**Section 96A of the Town & Country Planning Act 1990 (as amended)
Town and Country Planning (Development Management Procedure) (England) Order 2015 (as amended) -
Article 10**

Application No: EP/94/21/NMA
Site Address: St Johns Cottage South Strand East Preston BN16 1PN
Description of works: Non-Material Amendments following grant of EP/77/19/HH comprising fenestrative changes to approved extensions and alteration to the roof of first floor to the southern rear elevation.

South Elevation (Rear)

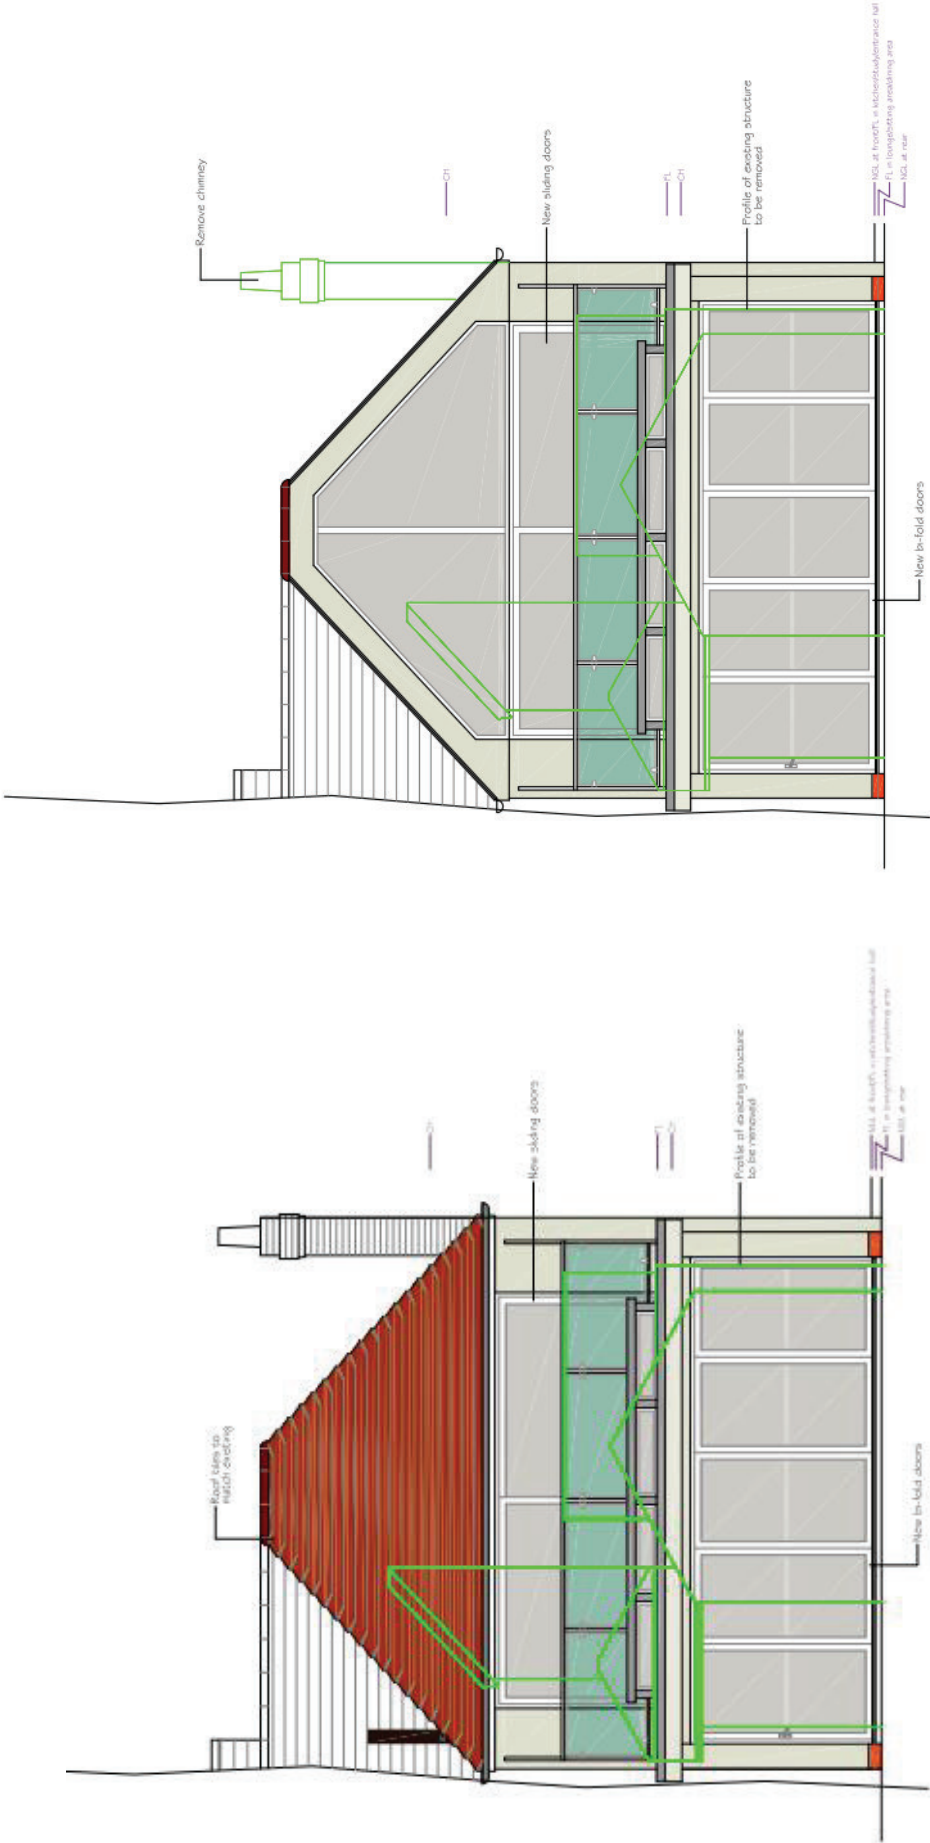
The committee does feel that this Application should not have been a non-material amendment. At the rear of the property, the whole of the roofline is proposed to be changed which seems a material change to us. We would appreciate an explanation of why ADC decided this was an NMA application. Thank you.
